Consultation Response from KC, Conservation & Design

2023/91855 23-25, Bradford Road, Dewsbury, WF13 2DU

Discharge conditions 10 (winch), 14 (Level 3 archaeological building record), 16 (internal doors, windows, etc) on previous permission 2019/91120 for Listed Building Consent for conversion and alterations to existing building to create 27 apartments

Date Responded: 22.8.2023

**DESCRIPTION:**  
WINCH POSITION

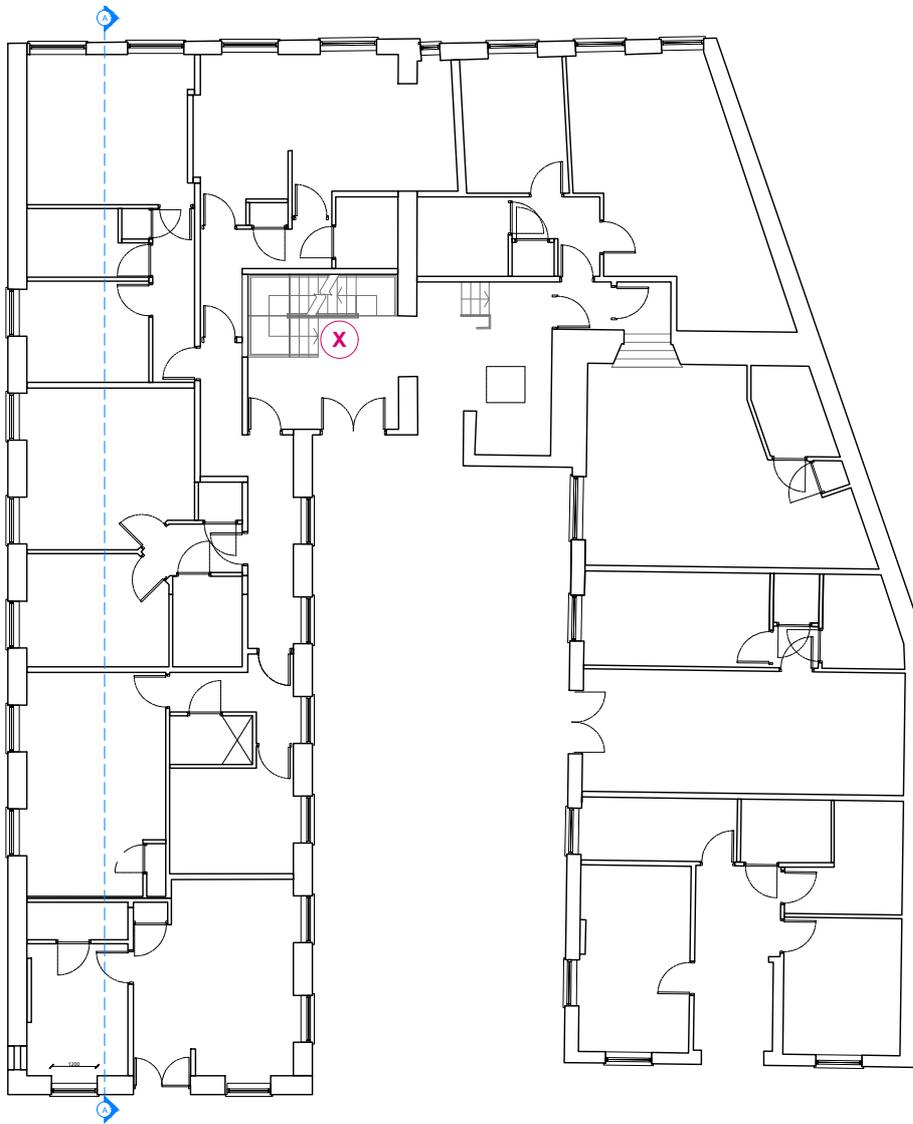
An annotated ground floor plan has been submitted showing the proposed location of the winch. The annotation states that the winch will be placed in a protective covering and stored in the basement during the works, then relocated to the position indicated and housed in a glazed enclosure, along with an interpretation board.

The submitted plan provides insufficient information to meet the requirements of Condition 10. There is no information on who will remove and install the winch, how it will be repaired and displayed, fixing methods and when this will be carried out. Further information is required to discharge this condition, and we would recommend that scale elevation and section drawings are submitted, along with a full method statement with proposals and images.
